17 Dene Road Northwood, HA6 2BS

(Arboricultural Method Statement [AMS])

**London Borough of Hillingdon
Planning Condition No. 11**

Update: 09/10/2025
Ref: 101 160

**17 Dene Road N/wood  
Condition 11 (Foxdell)**

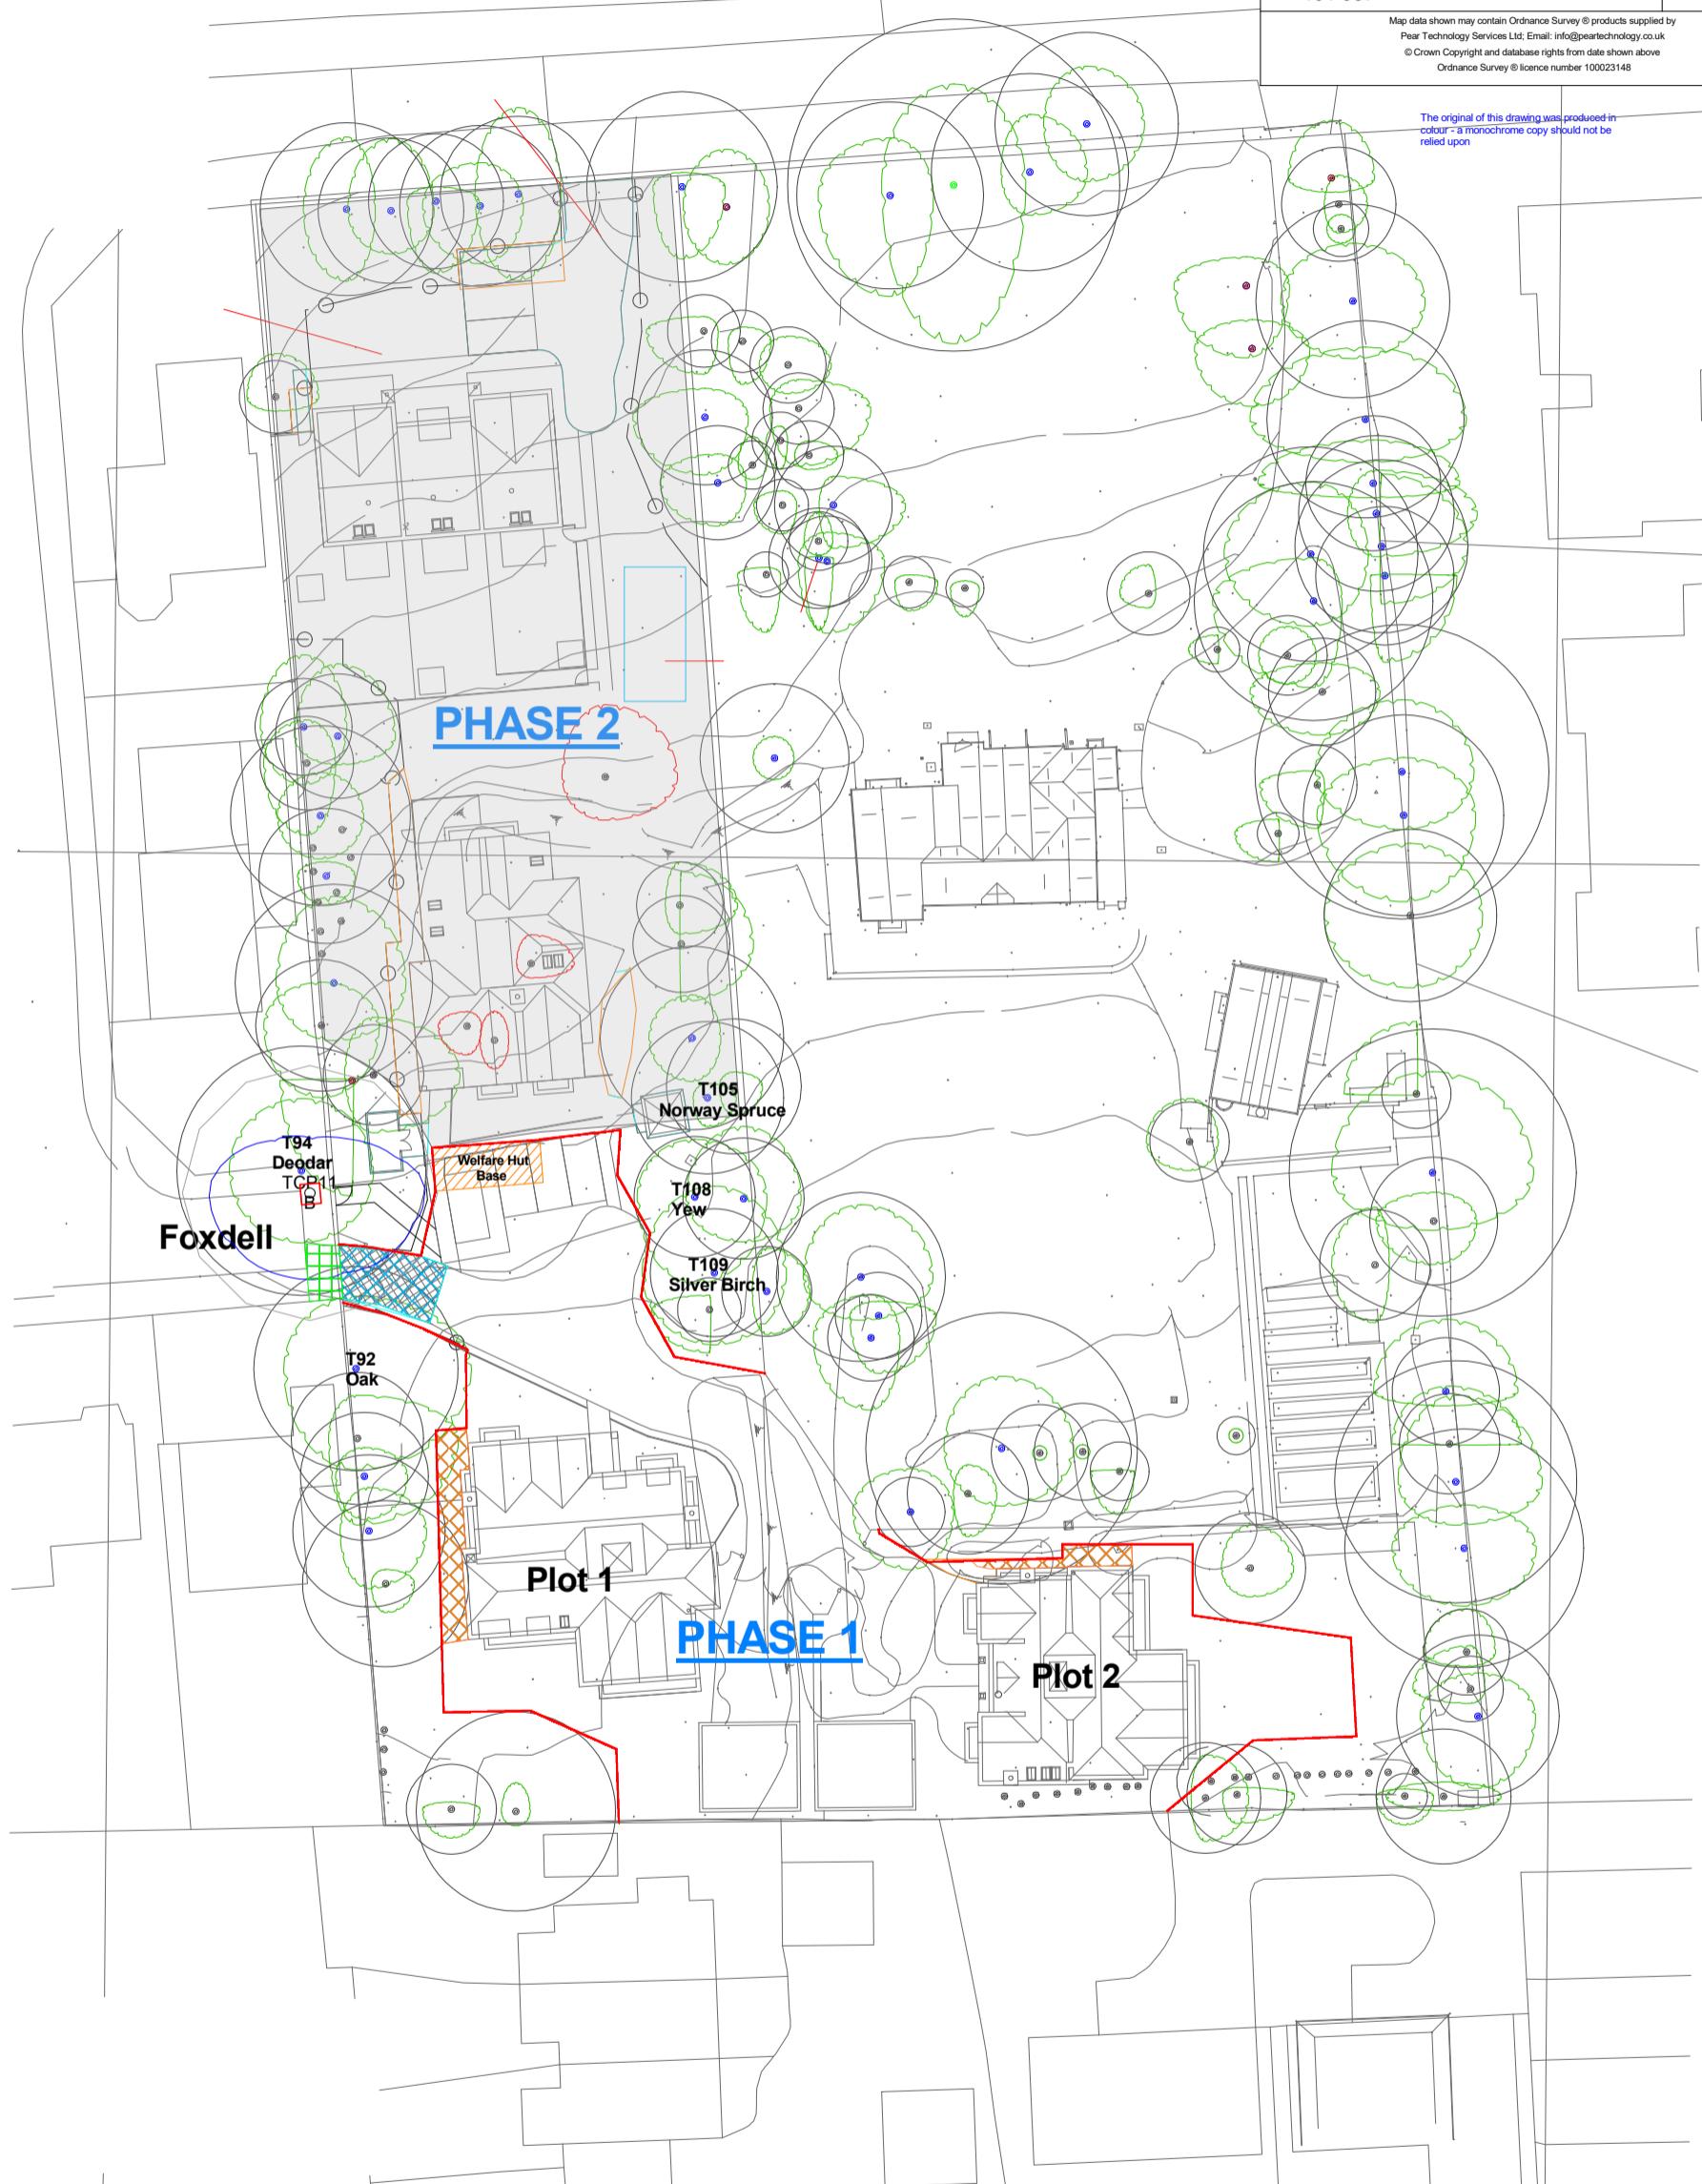
'From the plans, they are going to put a heavy-duty road-plate [green-hatched] over the footpath area to protect that section of Root Protection Area. They show this as only covering the footpath section and do not mention how they plan to deal with the kerb level change within this protection?'

Firstly, this heavy-duty road-plate was specified to protect the public-realm footway from (underlying soil) compaction from construction vehicles. Rationale: the area under this plate is within the Root Protection Area of TCP11.

Secondly, once the construction has been completed, a new drive over this public footway section will be created into the site passing by the aforementioned tree. See more details in section 4.4. of the appended AMS.
